Planning Application Ref: FP/257/17/T

Location : Open Space bordered by Copeland Road and The Ridgeway and Minton Road, Felpham

Description of works: Various works to trees on the green.

1. (A) 1x LARGE WHITE POPULAR TO REDUCE BY 4MTRS OFF HEIGHT & 2 MTRS OFF WIDTH.
2. (B) 1x HOLM OAK TO REDUCE 1MTR off THE SIDE HANGING OVER ROAD SIDE.
3. (C) REMOVE 1x HORSE CHESTNUT (HONEY FUNGUS).
4. (D) (E) DEADWOOD 2x LARGE PINE TREES.

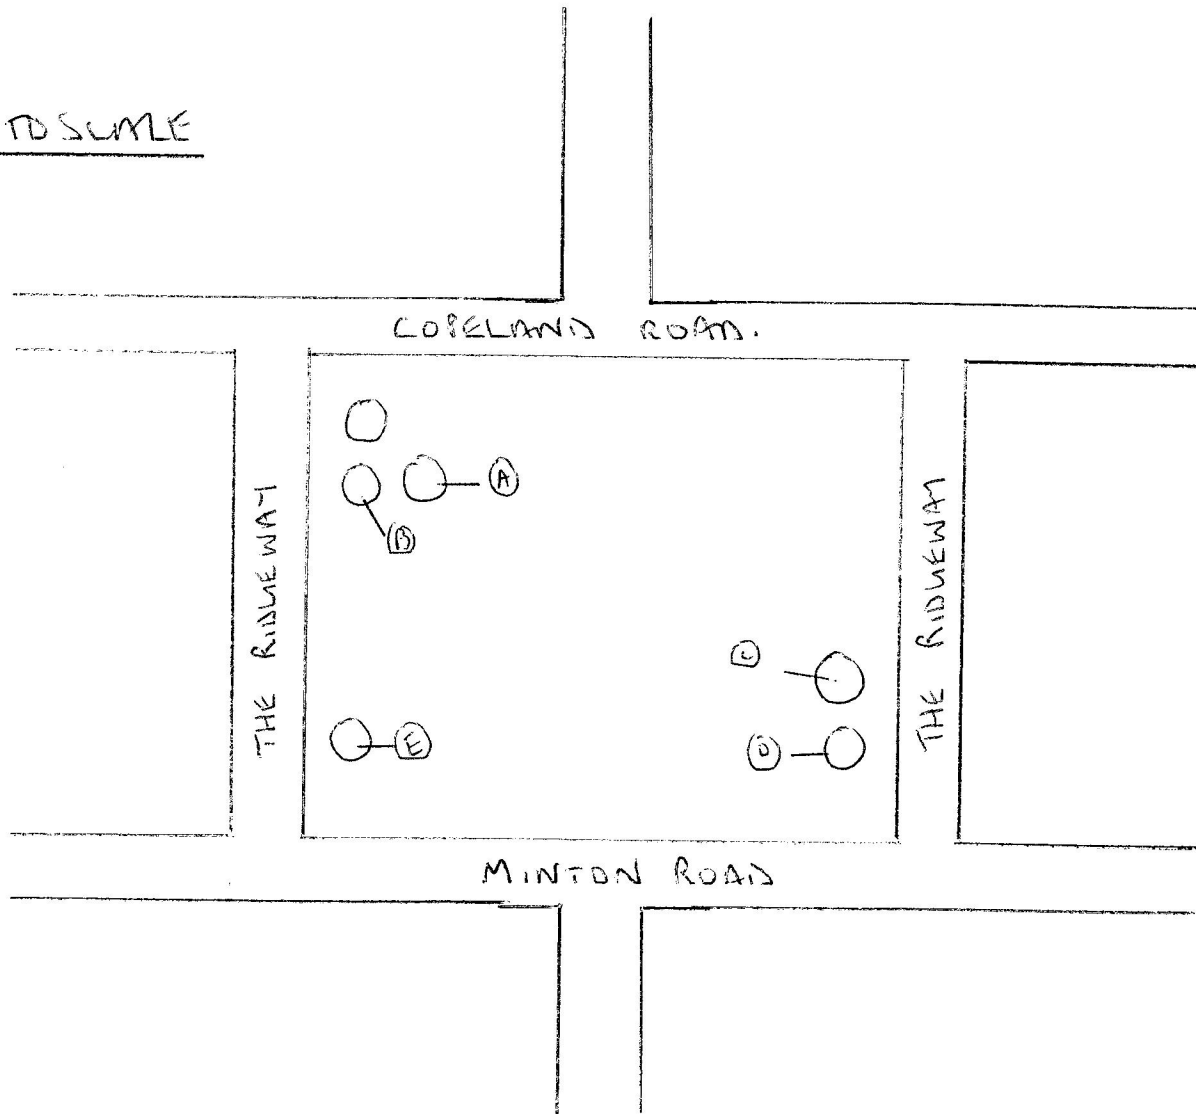
A Grey Poplar *Populus canescens* Height – 6m Avge Spread – 4m Age – Semi Mature

- Small tree with a utility cable through the upper crown

B Holm Oak *Quercus ilex* Height – 5m Avge Spread – 5m Age – Semi Mature

- Flat topped with a utility cable through the upper crown.
- Low overhang of the road to the west side.

C Horse Chestnut *Aesculus hippocastanum* Height – 5m Avge Spread – 3m Age – Semi Mature

- Extensive Bleeding Canker wounds throughout.
- Low vigour and vitality nd significant dieback.

D Pines *Pinus spp.*

- Small low branching trees.

A Grey Poplar *Populus canescens* - a small tree and removing 4m would leave just a trunk devoid of foliage totally undermining its value in the landscape and contrary to BS3998 recommendations.

B Holm Oak *Quercus ilex* - the low overhang of the road is a danger and must be dealt with.

C Horse Chestnut *Aesculus hippocastanum* - in a state of terminal decline.

D Pines *Pinus spp.* - do contain a lot of dead branches

A **Grey Poplar** - reduction by 4m in height and 2m in spread.

B Holm Oak trim back the lateral branches on the west side ONLY to clear back from the road –

C **Horse Chestnut** - fell and grub out the stump and plant a replacement tree – to be one of the following :

- Once the Chestnut tree has been removed in a safe and controlled manner and the stump and primary root runs ground or grubbed out a replacement tree is to be planted in its place.
- This is to be of **Standard Nursery Stock** – a tree of 8ft to 10ft in height and 8cm to 10cm in circumference staked and tied on a short staking system planted within 12 months of the original trees removal.
- It is to be one of the following species:-

Sweet Gum – *Liquidambar styraciflua* / **Ornamental Maple** – *Acer capillipes* or *Acer rubrum* or *Acer 'Davidii'* / **Foxglove Tree** – *Paulownia tomentosa* / **Indian Bean Tree** – *Catalpa bignonioides*

D **Pines** - permission is not required to remove deadwood.

1. ***Reduce in height by 2m***
2. ***Reduce lateral spread by 1m.***
